A G Wright & Son Farms Ltd

Sunnica – EN1010106

Unique ref nos: AFP 191

A/ **APP-115** – fails to comply with The British Society of Soil Science Guidance Note 1

Sunnica Energy Farm Proposed Layout - (Predictive BMV Land Assessment)

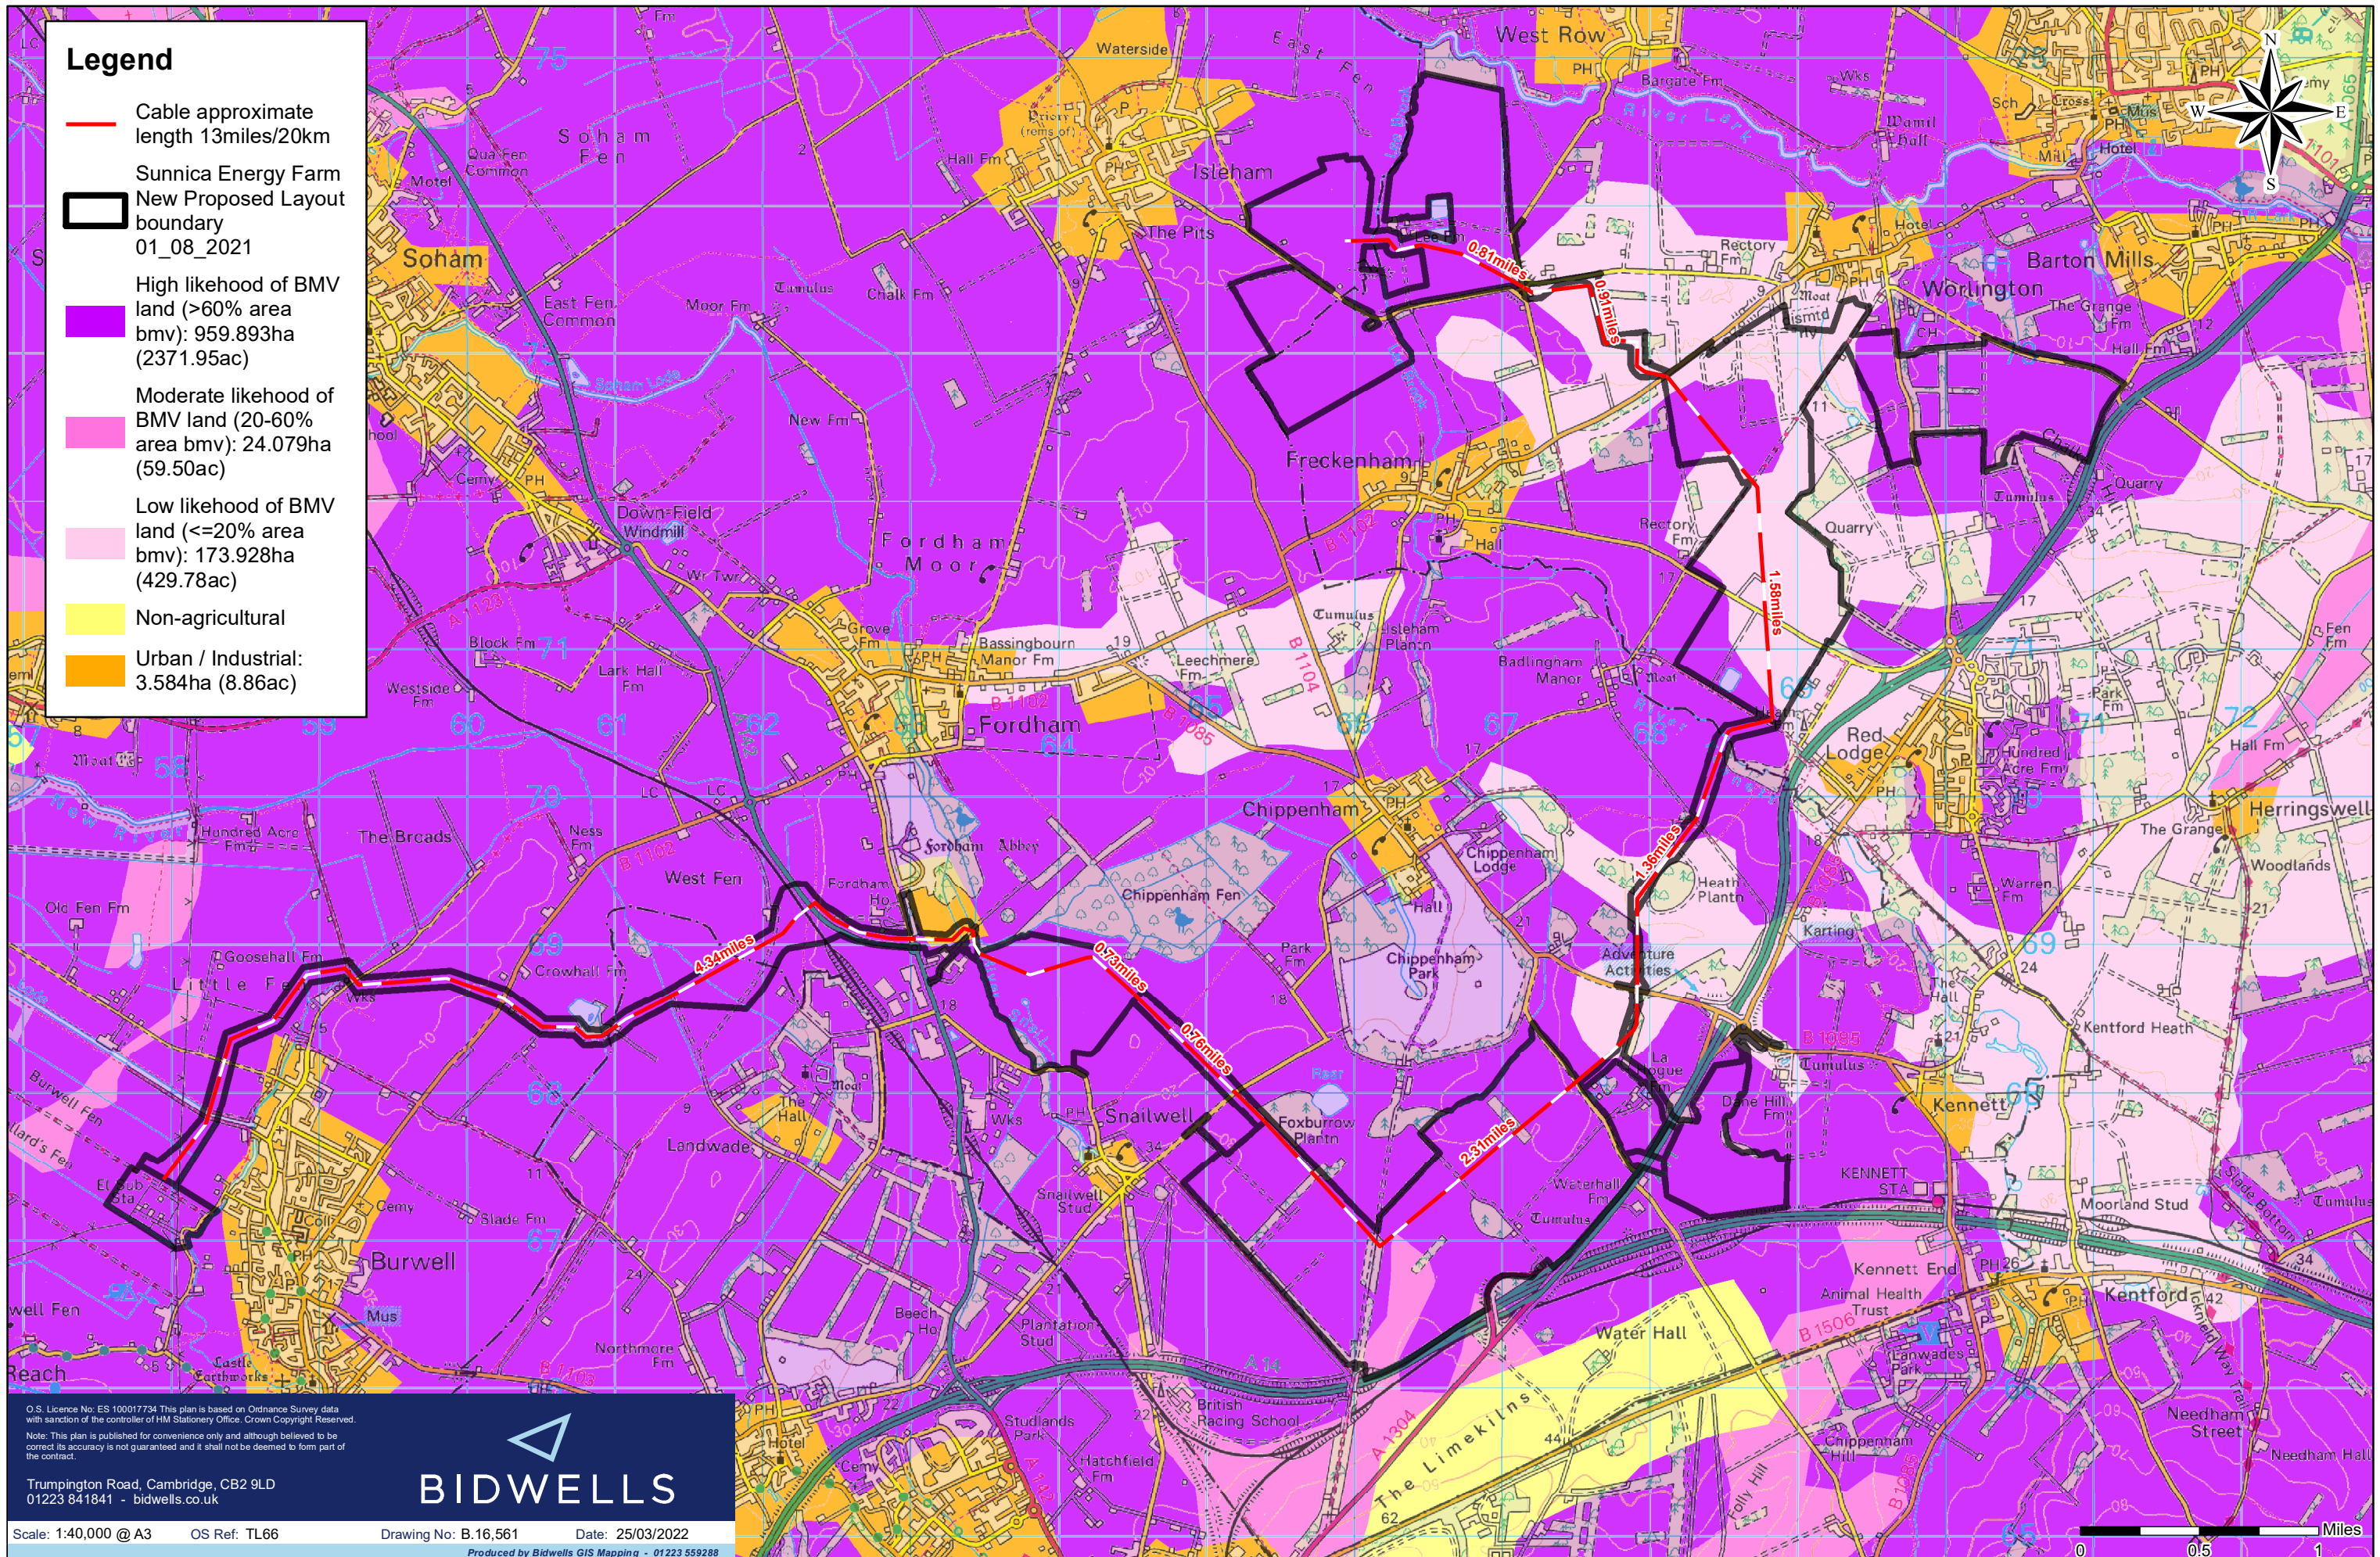
2/ The 2017 Natural England predictive BMV land assessment plan (appendix 4) shows 82% of the site as 60% or more likely to be BMV

We therefore must take the 2017 Natural England Predictive BMV land assessment plan as the document to establish the reasonable worst case for the likelihood of BMV on the site. The plan

identifies 82% of the site as potentially BMV. The Scheme should therefore be assessed on the basis that 82% of the site is BMV
